**Parramatta Leagues Club Hotel (SSD 8800) – 1 Eels Place, Parramatta
Notice of Exhibition**

Thank you for your letter dated 14 January 2019 requesting Transport for NSW (TfNSW) comment on the subject State Significant Development (SSD) application. The application proposes the development of Parramatta Leagues Club Hotel, intended for 209 hotel beds with ancillary uses (pool, gym, café, bars and function room) over 17 storeys, and vehicular access from O'Connell Street.

Figure 3: Proposed road extension for this application

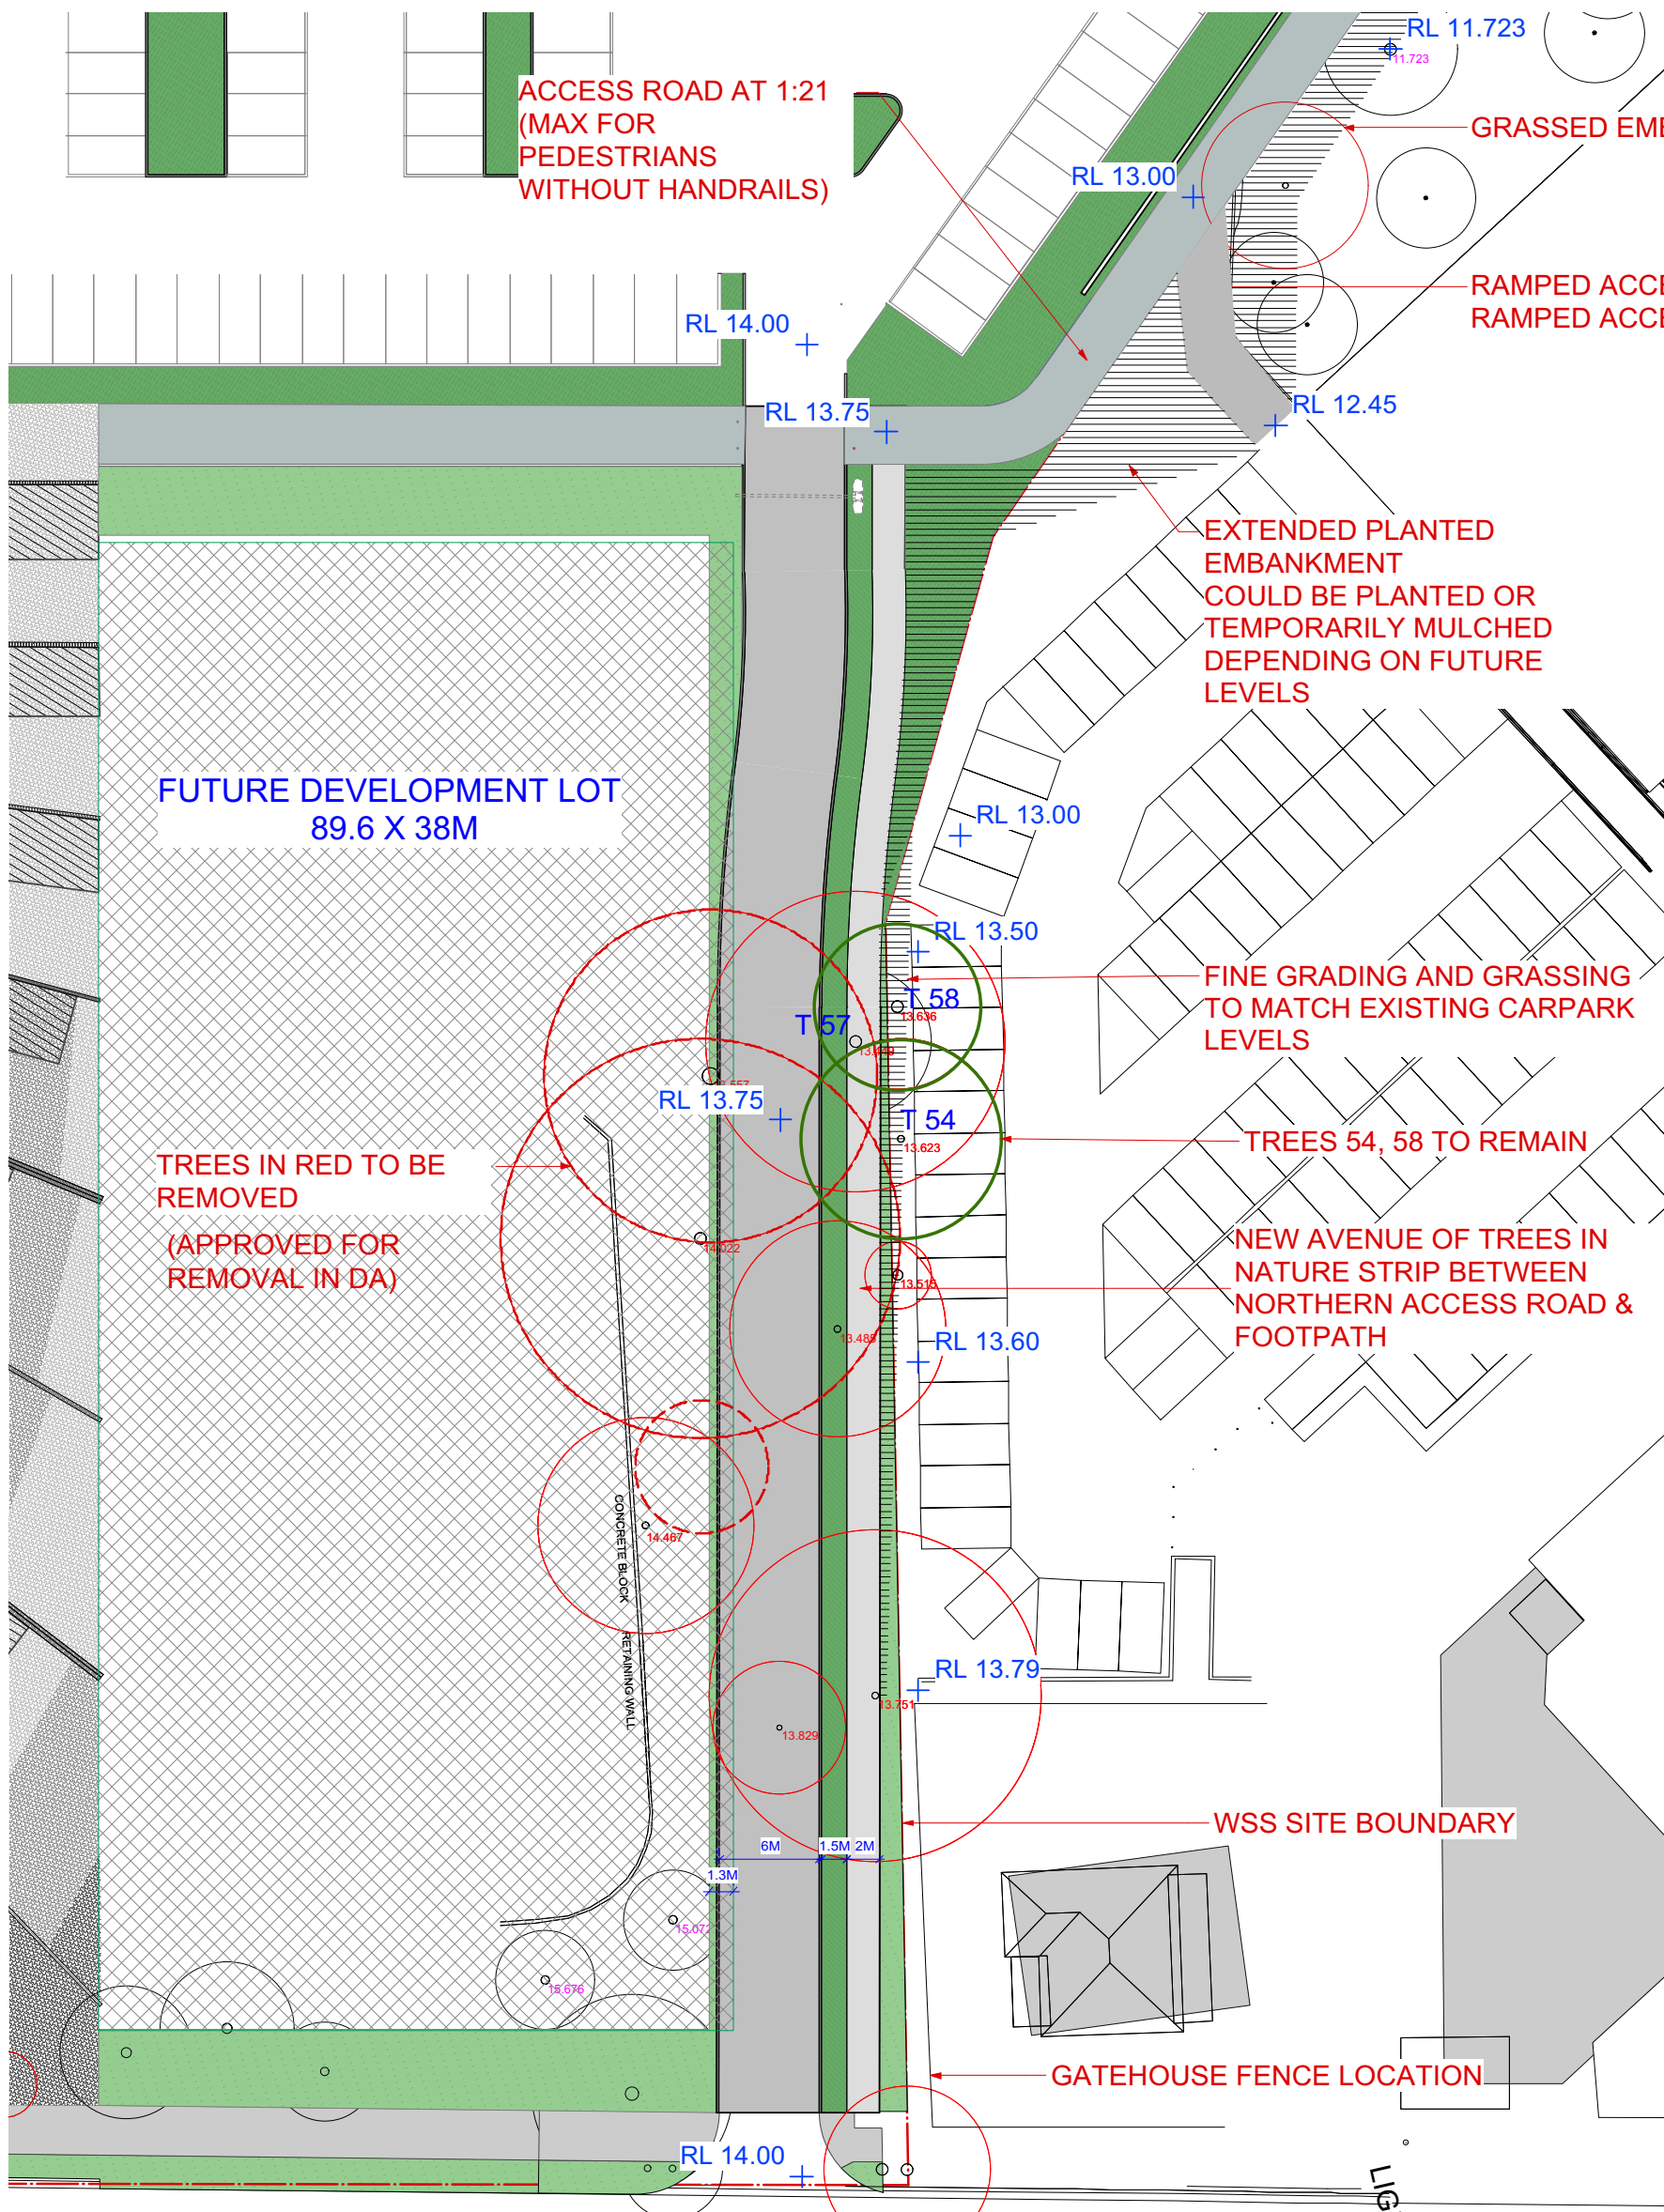
This access road is within the Venues NSW site, and provides left-in/left-out access from O'Connell Street. The access road forms part of an internal road system that provides access to parking areas and loading areas within the WSS site. It is unclear if there are any legal rights for the proposed development to use the private access road or if it will be dedicated as public road to Council.

The Transport and Accessibility Impact Assessment states that negotiations between the Applicant and Venues NSW, Lend Lease and Parramatta Park Trust seeking to widen the 6m access road are ongoing. The EIS further notes that formal owner's consent has not been secured for lodgement of the DA.

The hotel proposes a porte-cochere and loading dock facility which will be accessed via the new access road. The proposal seeks to widen the access road to 10m on the northern side of the road to accommodate coach and pedestrian flows to the stadium and hotel site.

- The applicant provide evidence that the access road would be available for use, which could include formal approval from Venues NSW to confirm owner's consent has been granted to Parramatta Leagues Club for the future use and widening of the access road for this proposal.
- Further details should be provided of the future use of the access road and whether the road will be dedicated as a public road.
- Further details of the timing and access arrangements of the future development of the building that will front the access road should be provided and considered as part of this proposal.
